From: Simon Davis
Sent: 21 May 2019 16:07
To: 'Lauren Wiltshire' [REDACTED]
Cc: Laura Gibbons <Laura.Gibbons@arun.gov.uk>
Subject: RE: Planning Consultation on FP/42/19/DOC

Engineers Comments Regarding Condition 7

Site Address: Land off Stanhorn Grove Stanhorn Grove PO22 8FS

Description of Works: Approval of details reserved by condition imposed under ref
FP/171/18/PL relating to Condition Nos
5,6,7,8,9,10,11,12,13,14 & 24.

NB: Sub-base construction depths are shown as minimum construction requirements. Specific construction depths vary, e.g. where sub-base falls (to collection point) in opposite direction to surface falls. See respective Drainage Layout for specific sub-base levels.

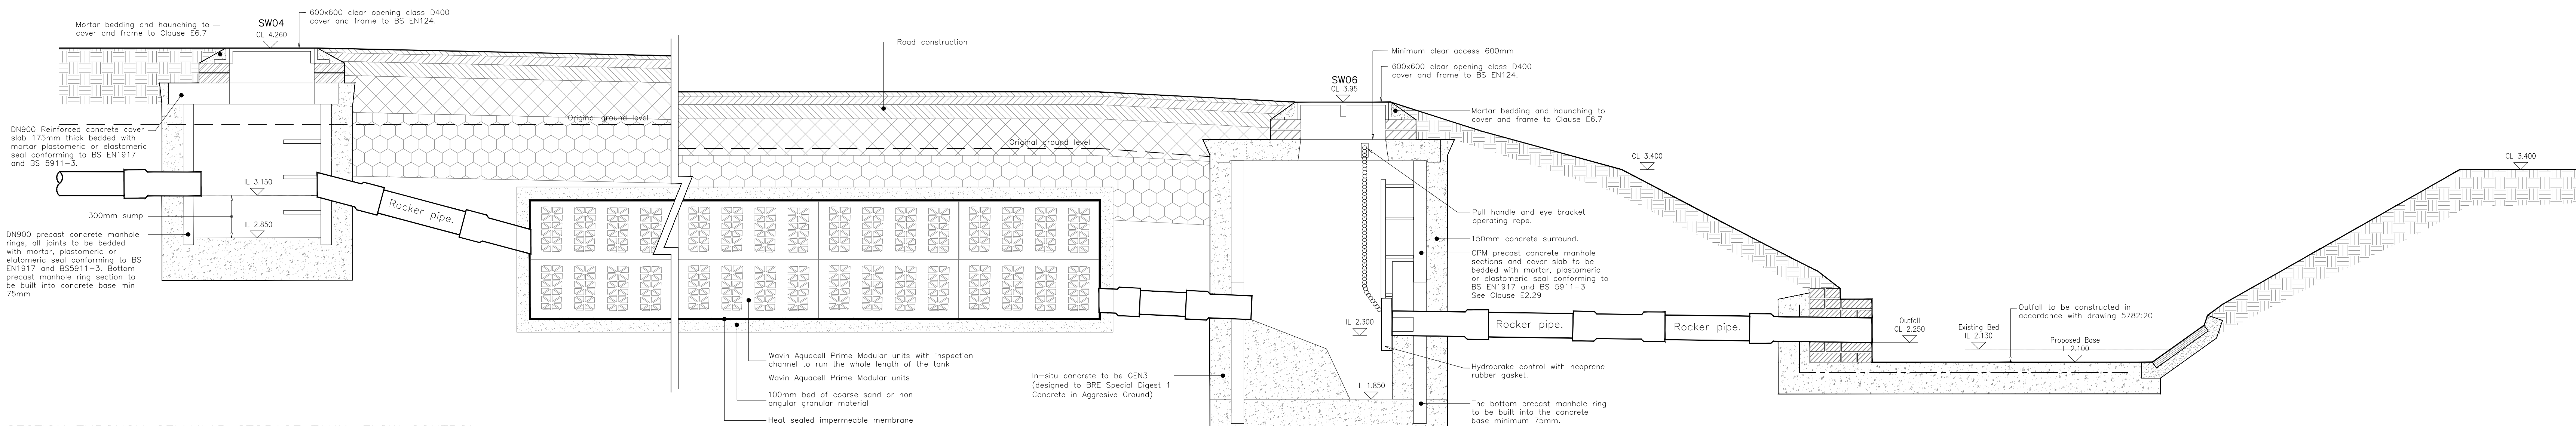
1. Catchpits must be provided upstream of all connections into the attenuation tank.
2. No construction detail drawings have been provided. Please provide construction detail drawings of manholes, catchpits, permeable paving, attenuation tank and hydrobrake.
3. There is conflict between the landscaping proposals and the drainage proposals. Trees must not be located on or near attenuation tanks. Please revise the landscaping proposals.
